Application Reference: 2026/0639

Site Address: 57 Mitchelson Avenue, Dodworth, Barnsley, S75 3JN

This application seeks full planning permission for a front single storey extension and rear attic dormer.

Drawing Title
Proposed Elevations
A3

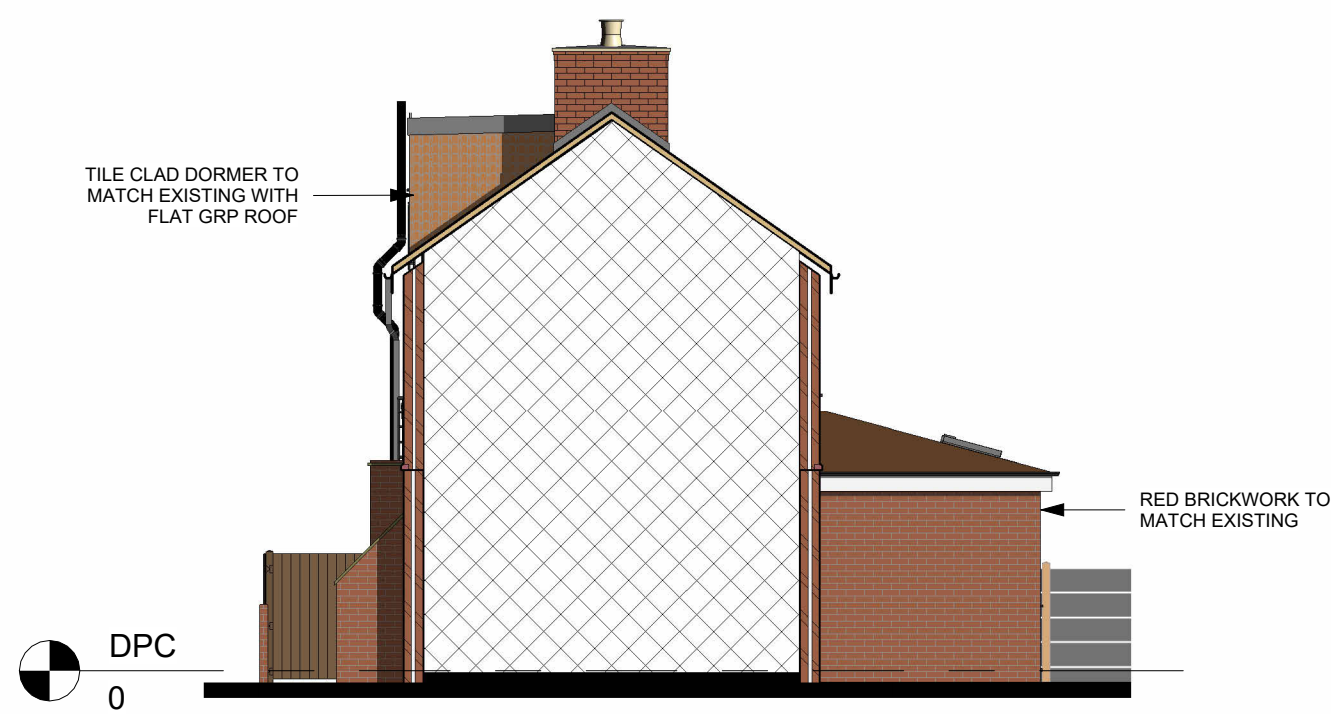
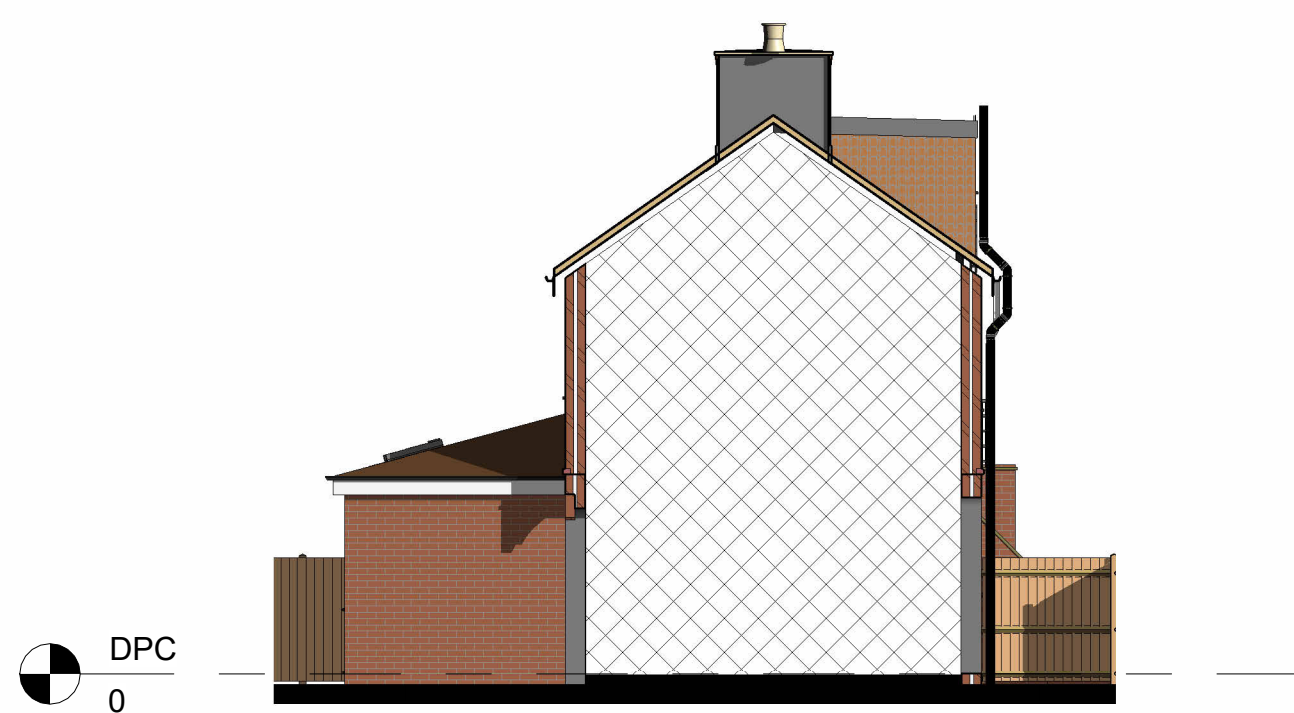
The proposed extension would have a tiled hipped roof, which matches the roof style of the front single storey extension on the neighbouring property. The extension would be approximately 7.9 metres wide, extending across the majority of the front elevation of the dwelling. The front elevation of the proposed extension would extend approximately 2.9 metres towards the front of the property and would be approximately in line with the existing extension at the front of the neighbouring property. Although the dimensions of the extension may not usually be considered modest, within the context of the existing street scene and extension on the neighbouring property, an extension of these dimensions would have a minimal negative visual impact on the overall street scene.

The proposed dormer features a flat roof, which the House Extensions and Other Domestic Alterations SPD recognises as an inferior form of construction. However, the construction of the dormer would utilise similar materials to the host dwelling and is located at the rear of the property, reducing the negative visual impact on the character of the dwelling and street scene. Generally, the installation of the dormer could be completed without planning permission. Therefore, the proposed dormer is deemed acceptable.

The proposed includes two windows on the front elevation of the single-storey front extension. These would face the street and have an approximate distance of 30 metres to the side gable wall of the dwelling on the opposite side of the road. Therefore, the introduction of these windows is unlikely to result in harmful overlooking or loss of privacy for neighbouring occupiers and is considered acceptable in terms of residential amenity.

The installation of the dormer would include the installation of windows and a Juliette balcony on the second floor. The windows would be in line with the existing rear elevation and therefore, there is no increased potential for direct overlooking. Generally, the installation of the dormer could be completed without planning permission.
